Planning Application Ref: A/156/19/T

Location: Tall Trees, High Street, Angmering, BN16 4PQ

Description of works: Remove all limbs overhanging 1 Alexander Avenue by 2m to 1 No. Monterey Pine and remove all pine cones within catchment of 1 Alexander Avenue

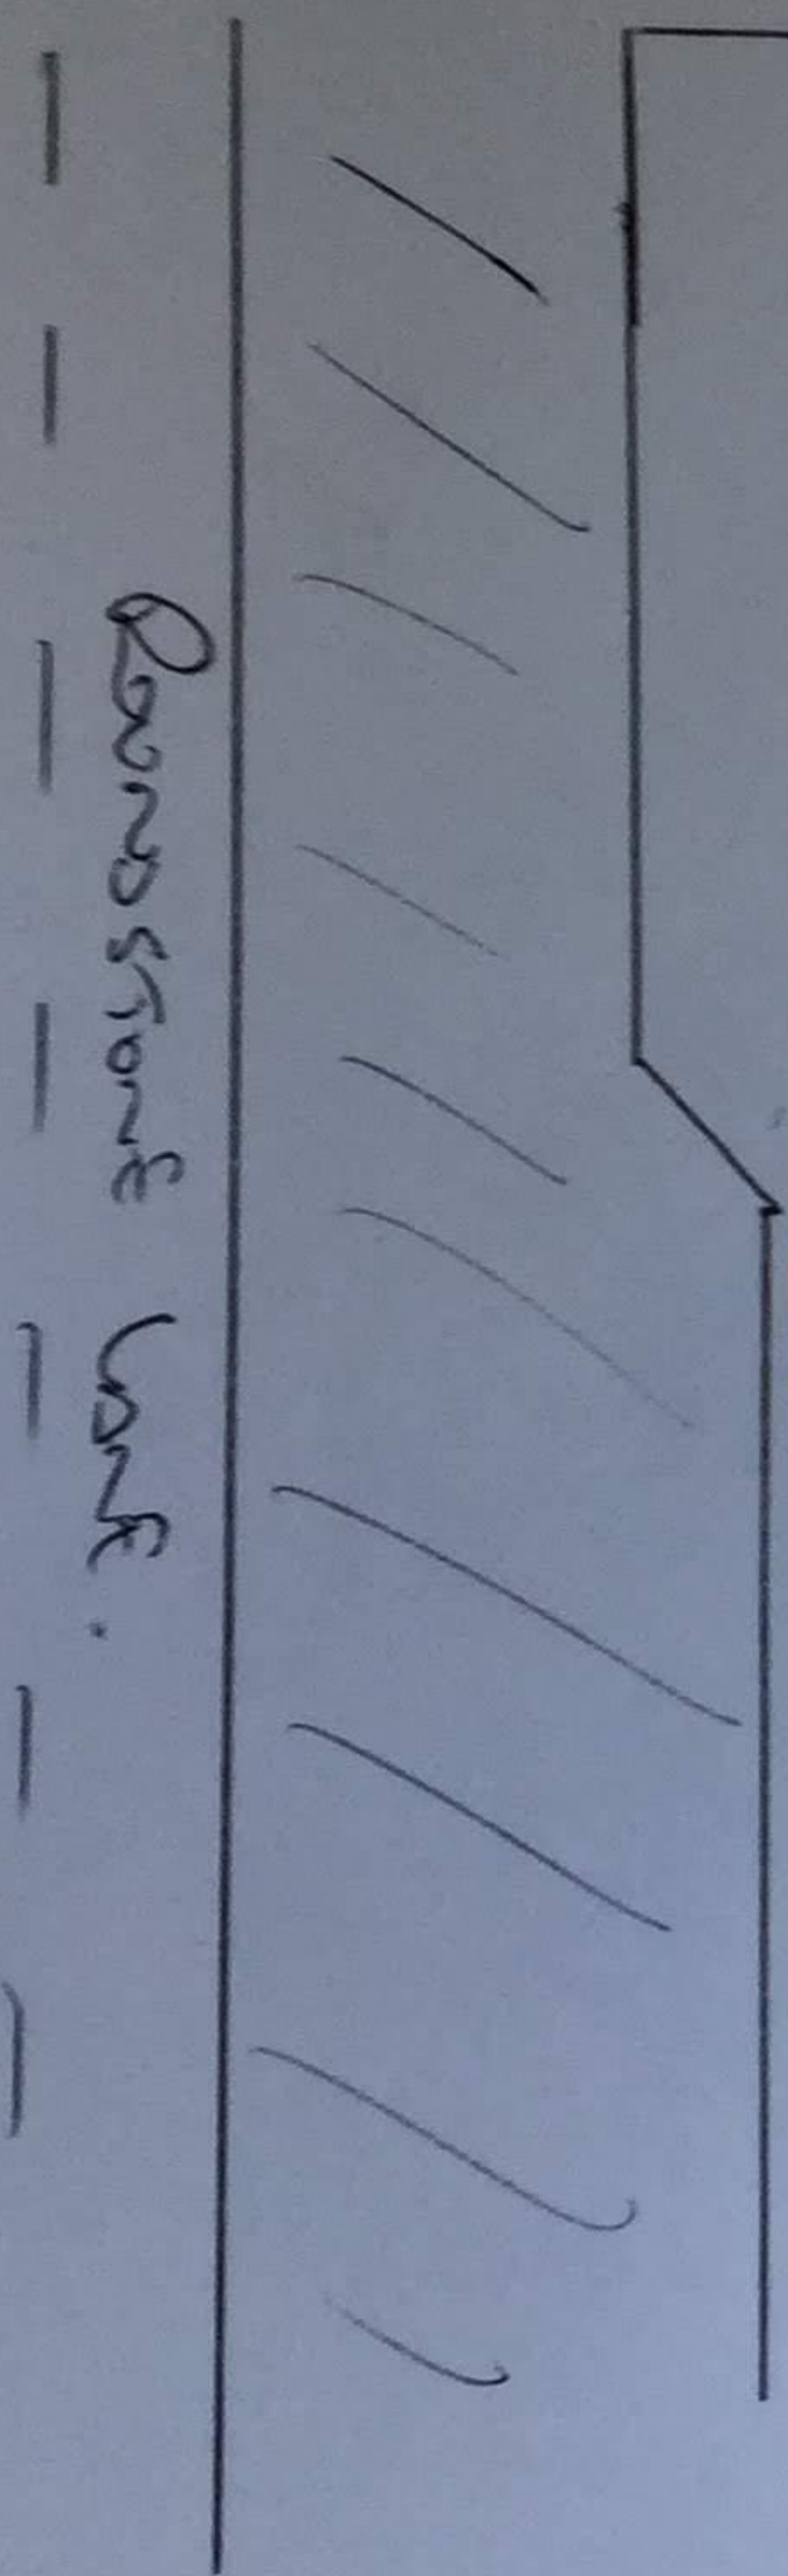
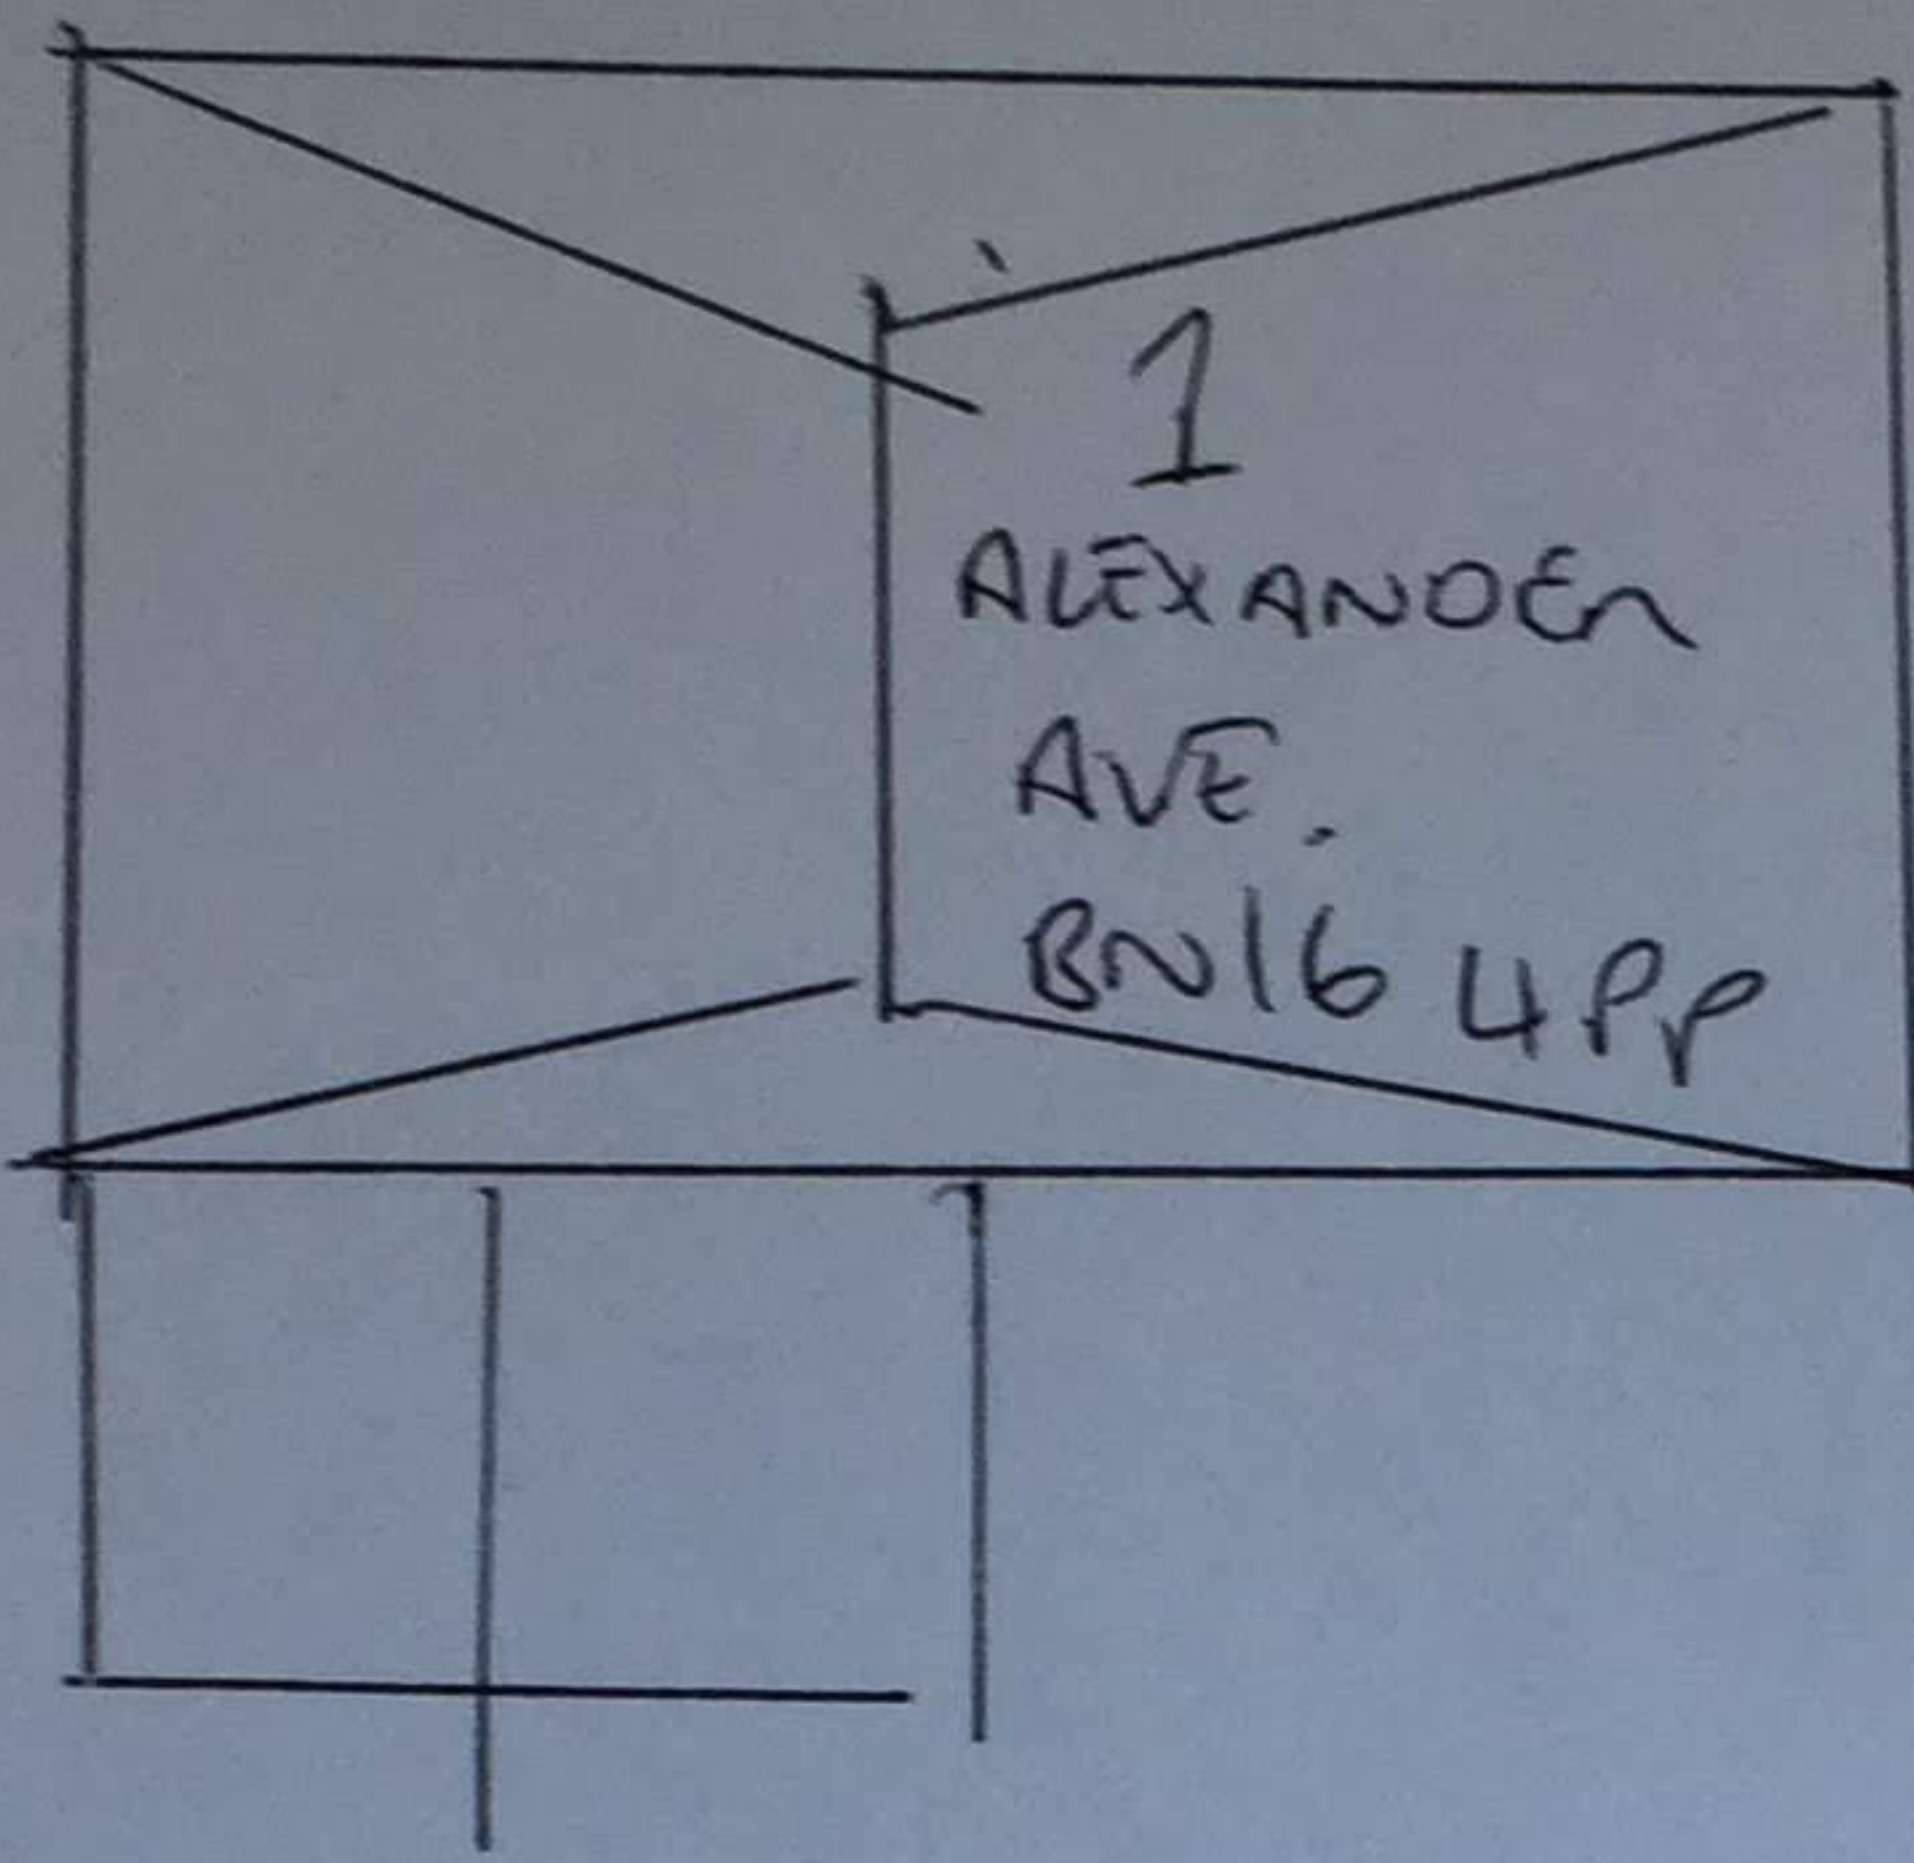
- By way of abating a nuisance from encroachment, it seems reasonable to seek the reduction of carefully selected branches to reduce the overall crown spread (on south aspect) but that is not what is being sought here. The applicant asks for the removal of all limbs overhanging by 2metres, which is an ambiguous work proposal and by one interpretation would result in severe detriment to the visual amenity of the tree on its most publicly visible aspect.

- As it stands, I recommend **REFUSAL** for this application.

- I would like to see the applicant submit a revised work specification such as detailed below, which would seem to address their concerns whilst preventing a diminution of the tree's landscape and public amenity value:
 - Reduce crown spread (south aspect only) by maximum of 2metres
 - Remove all Monterey pine cones with potential to fall into property of 1 Alexander Avenue
